PROJECT: WALDEN CORPORATION WWTP  
 3155 WALKER ROAD COLORADO SPRINGS  
 EL PASO COUNTY, COLORADO  
 ENGINEER: AQUAWORKS DBO, INC.  
 3252 WILLIAMS STREET  
 DENVER, COLORADO 80205  
 (303) 477-5915

SHEET TITLE:  
 LAGOONS CLOSURE PLAN  
 PROJECT NUMBER: #3774  
 SCALE: 1"=100'  
 SHEET: C10

# V3\_ Pond reclamation.pdf Markup Summary

SHEET TITLE:
LAGOON DECOMMISSIONING, GRADING AND RESTORATION
 PROJECT NUMBER: #3774
 SCALE: 1" = 80'
 SHEET: C12

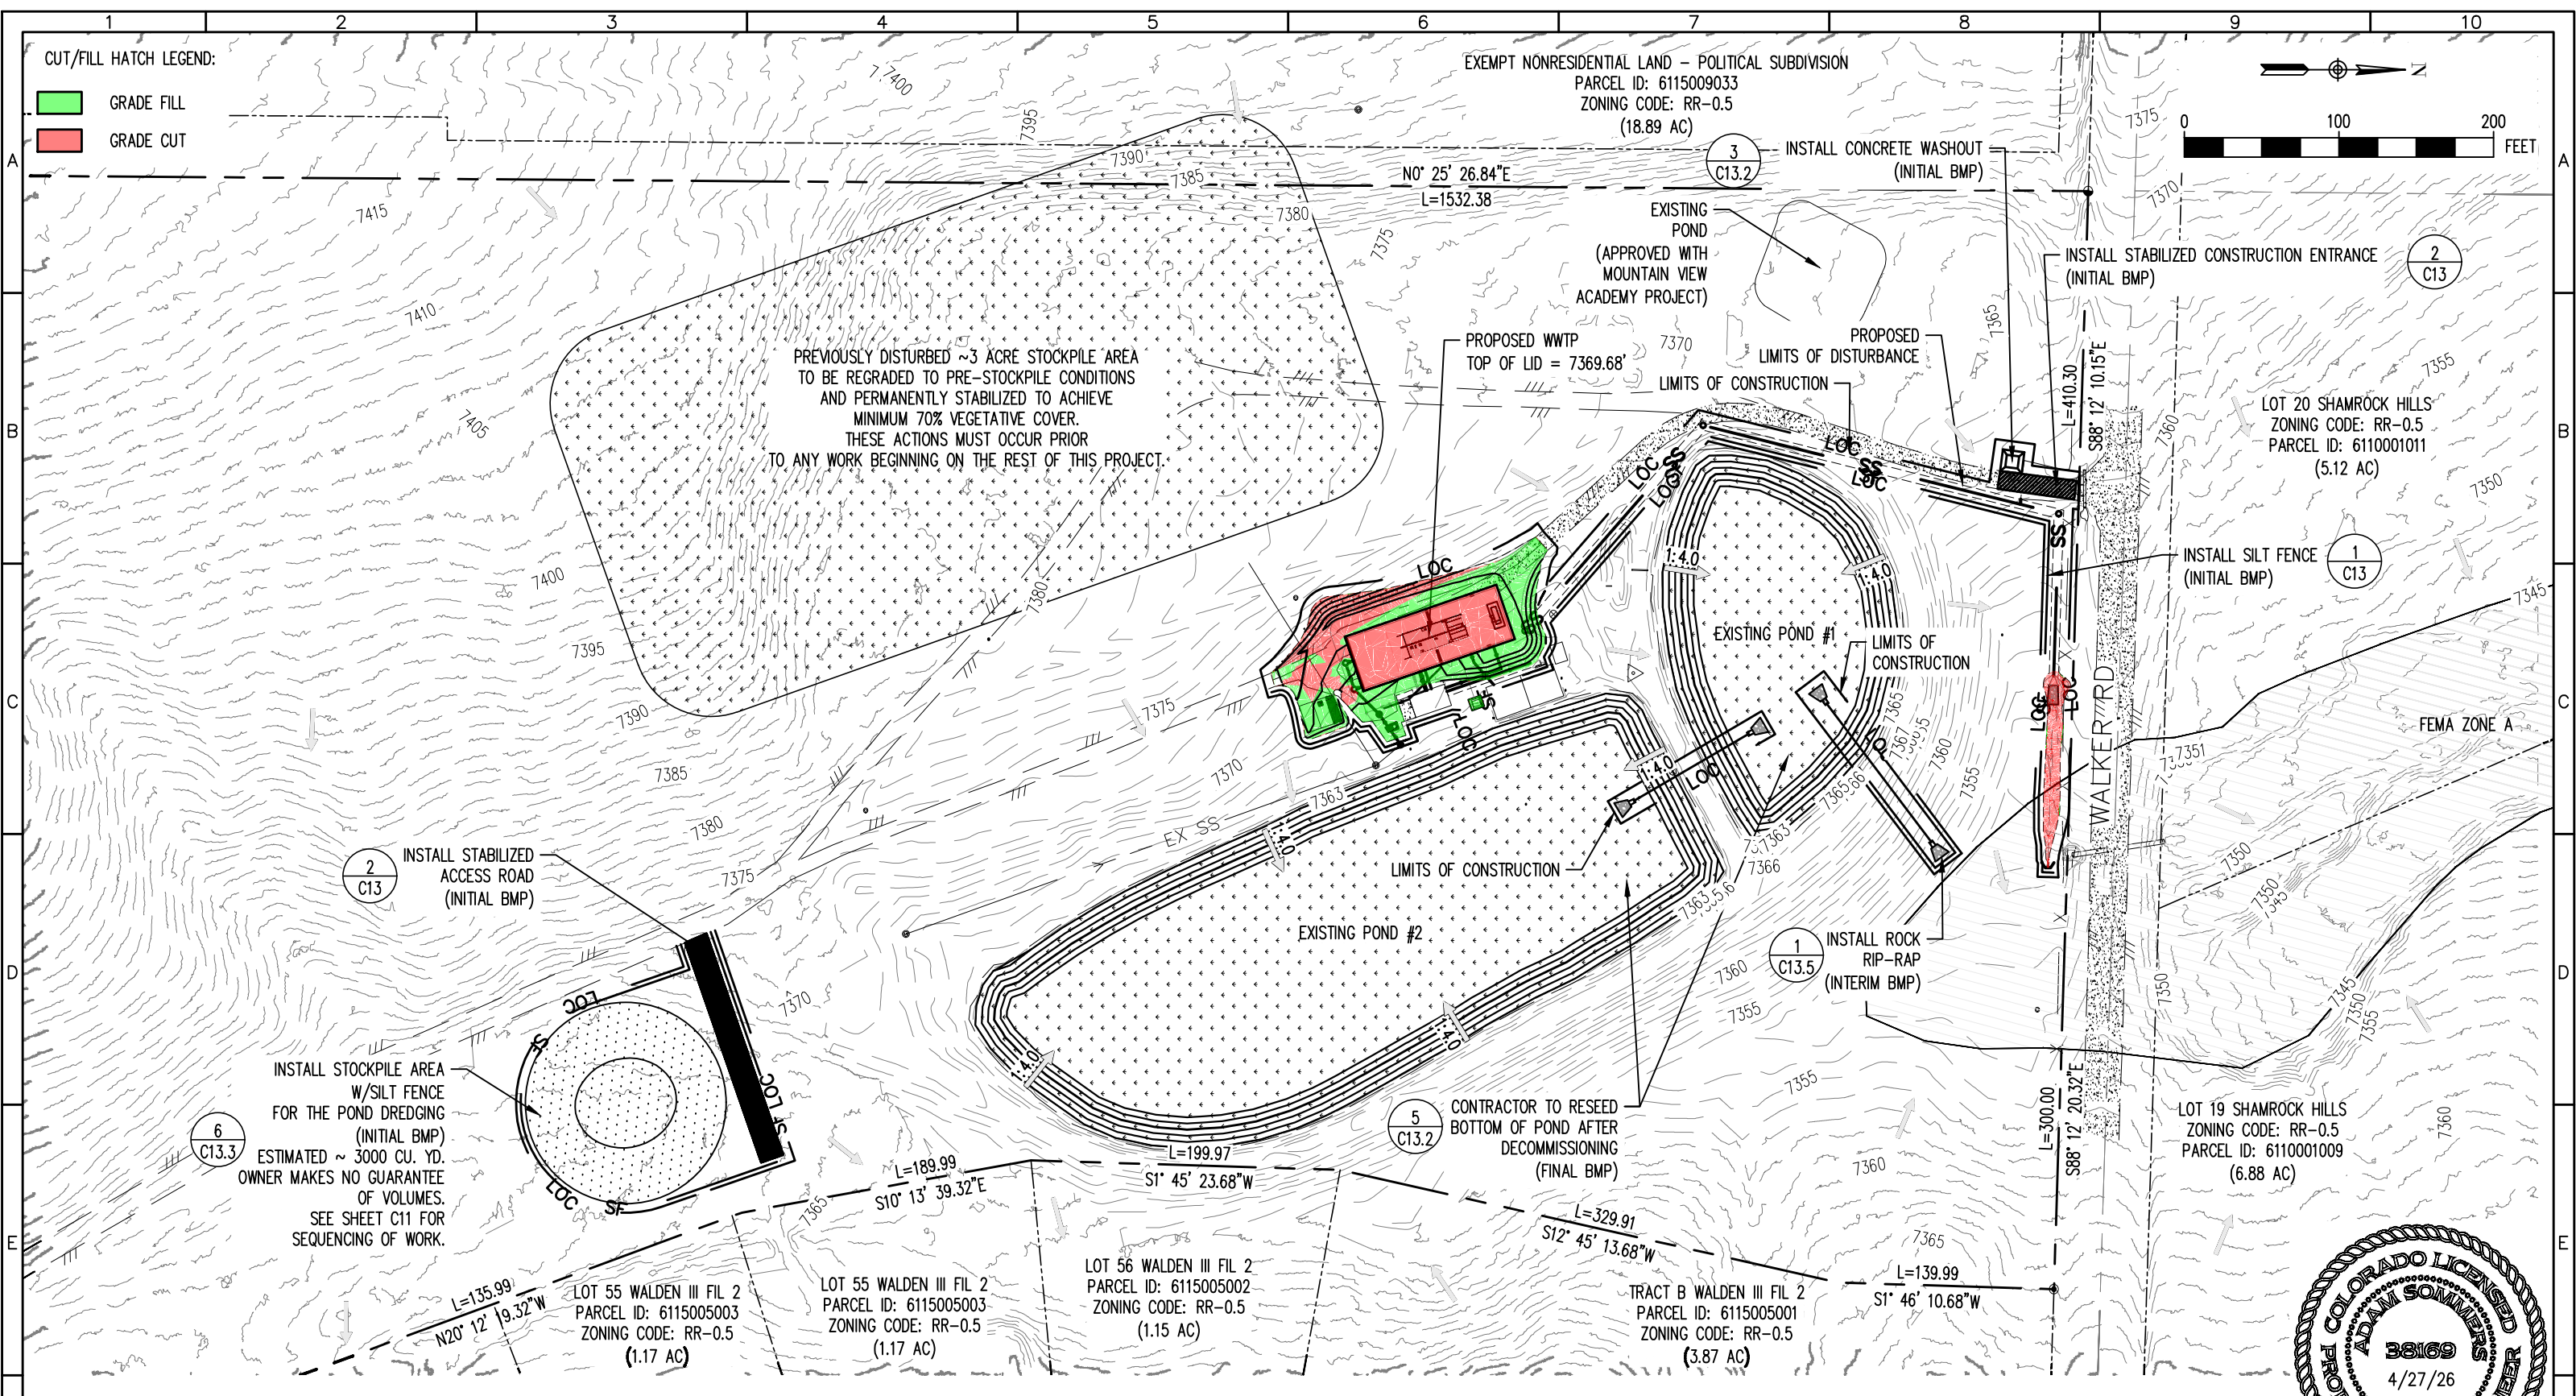
Show the anticipated dewatering operation on GEC plan and provide details.

See note on GEC plan. Reclamation plan must match GEC plan.

Please include a sheet of the pond in its final reclaimed state, including vegetation, pipes, and grading,

Contractor is responsible for setting up the dewatering pumps and pumping the water back up into the proposed WWTP as part of startup.

Sheet showing ponds in their final reclaimed state updated as per request.
